SSD_7056: CAMPBELL'S STORES, THE ROCKS

MODIFICATION REPORT BAY 11

URBIS

Drawing Title  
**ELEVATIONS**  
JPW Project Number  
**12006**  
Drawing Status  
**EA**  
Drawing Number  
**EA-A-2000**  
Revision  
**D2**

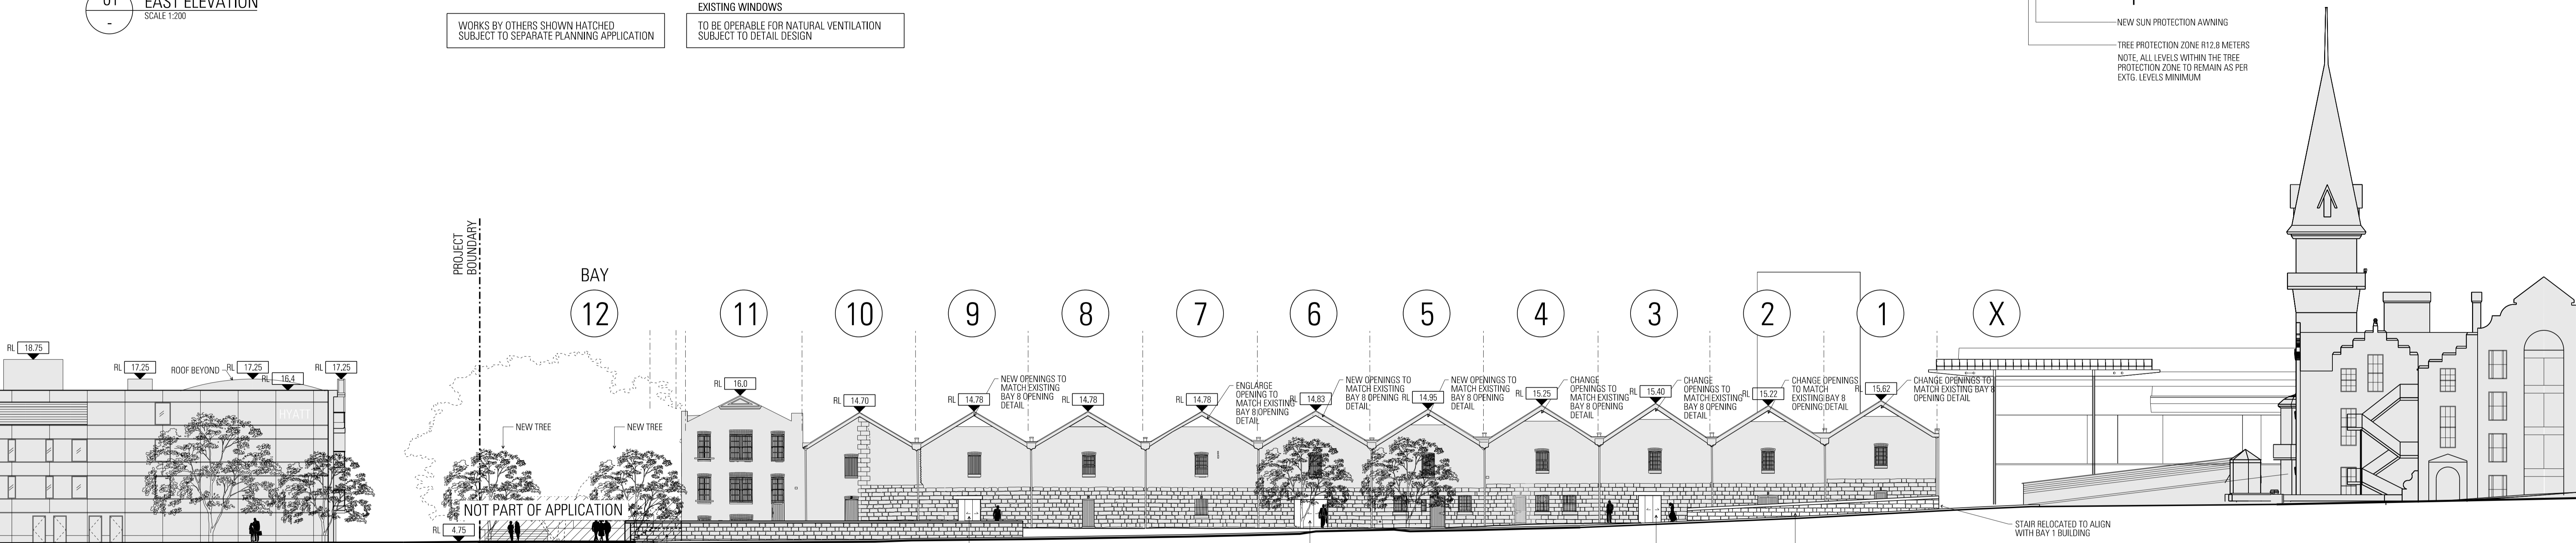
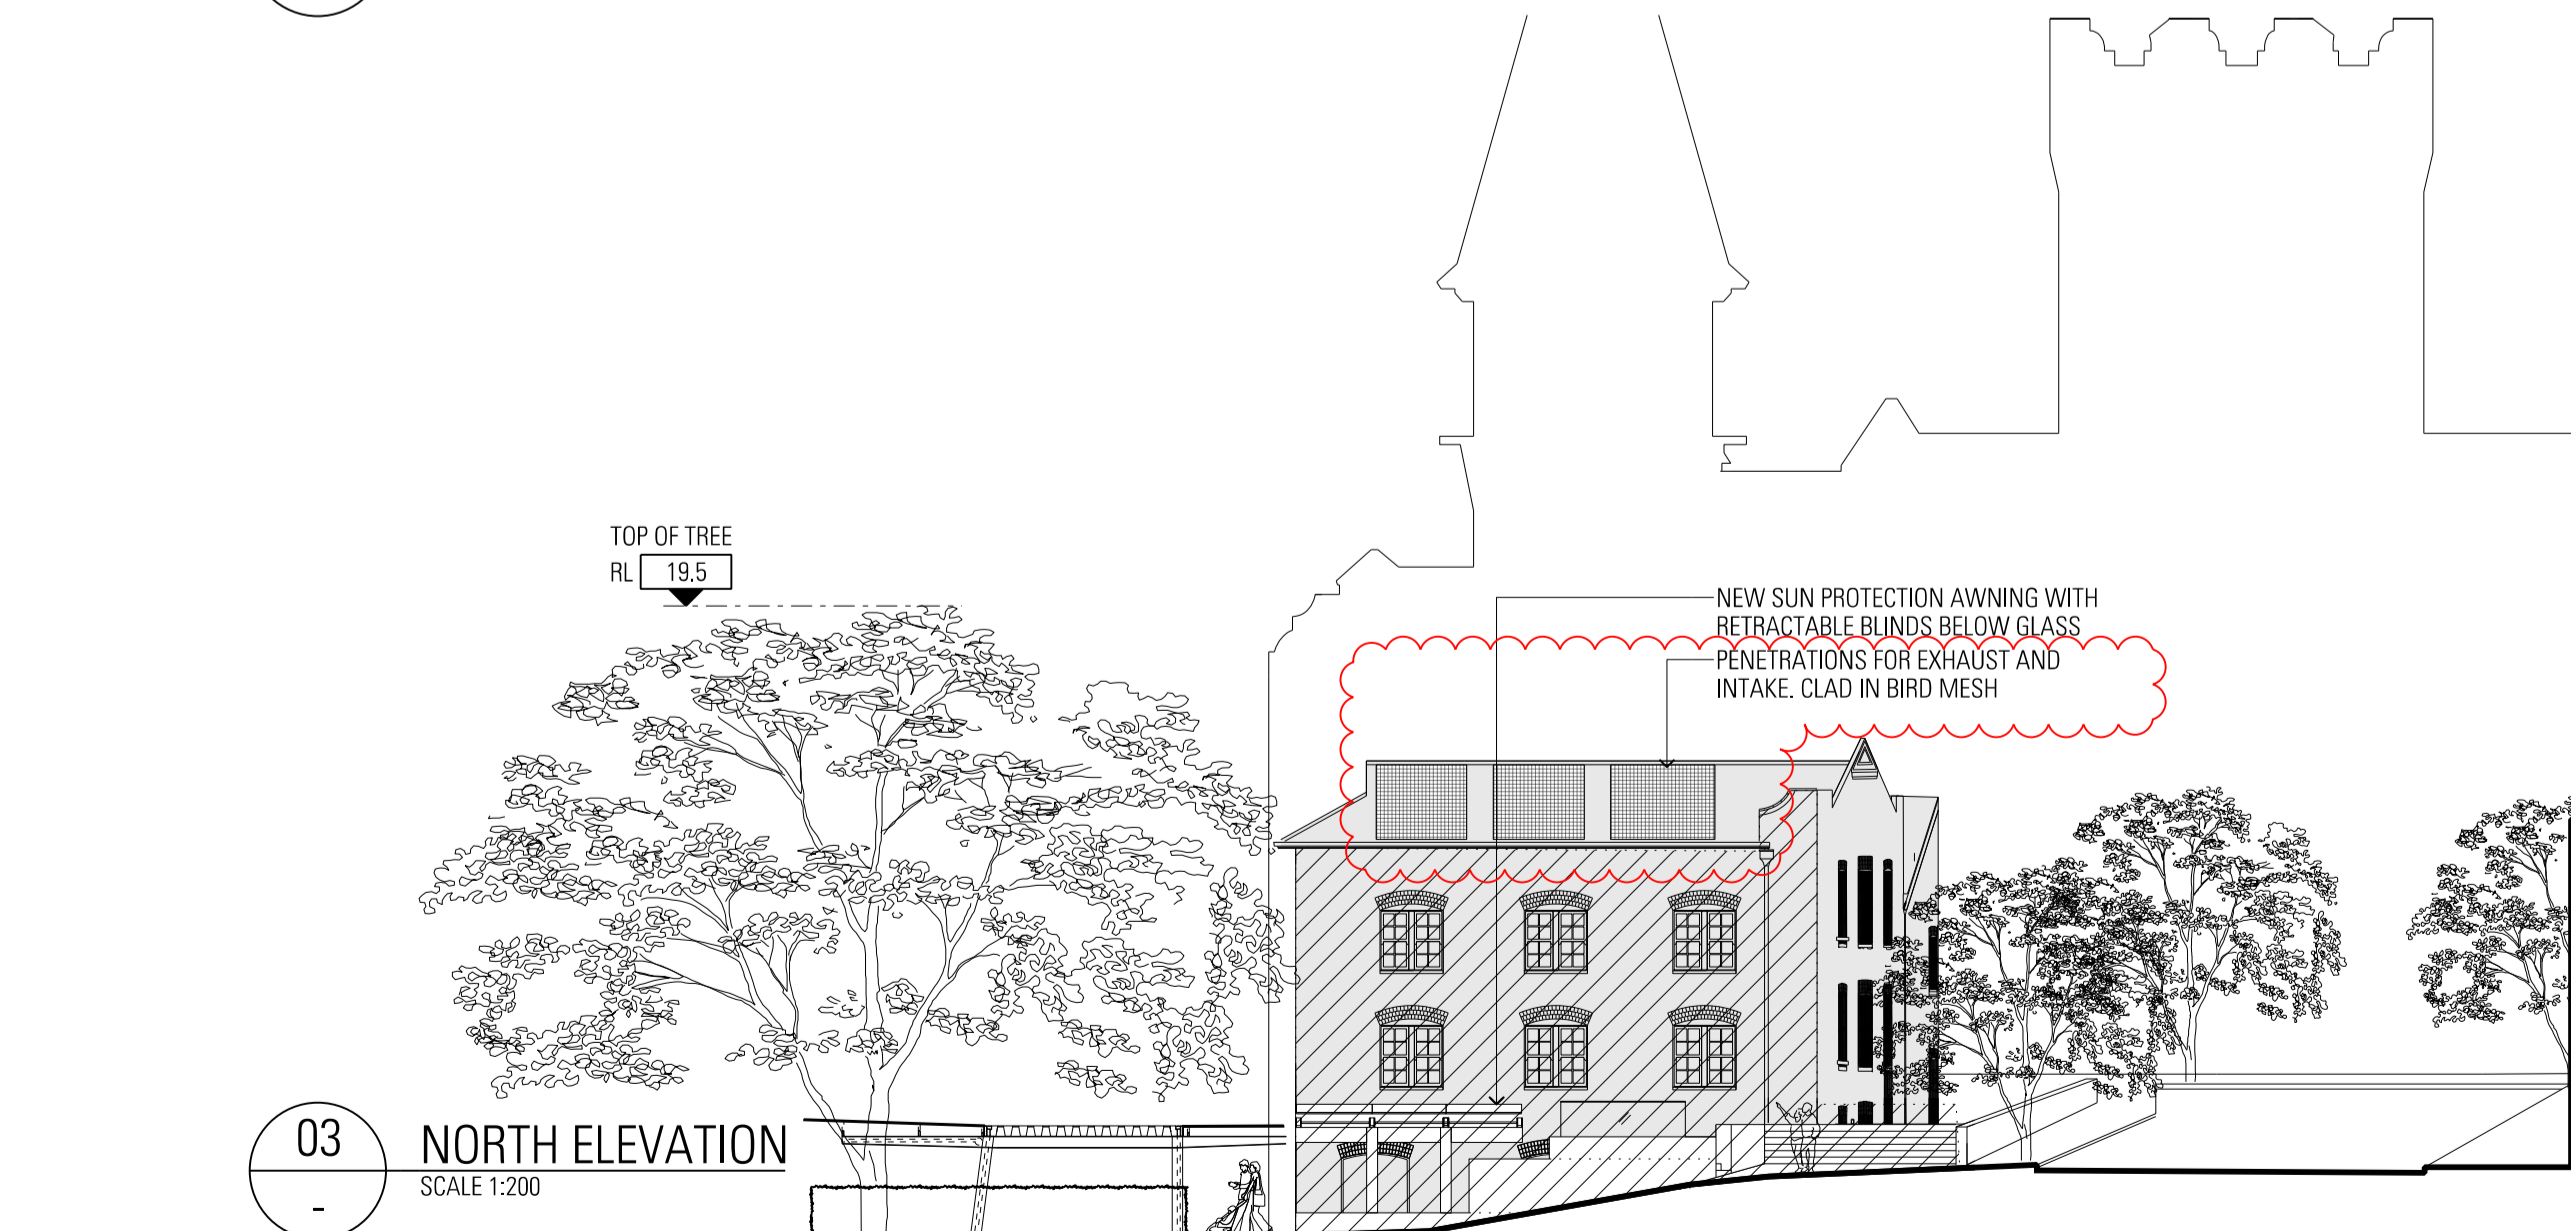
To prevent hot air build up below the skylight within the Bay 6 roof, it is proposed to provide two small air vents hidden behind the eaves on the eastern side of the building (refer Figure 5). This is similar to what is already approved in Bays 3 and 9 for the toilet exhaust.
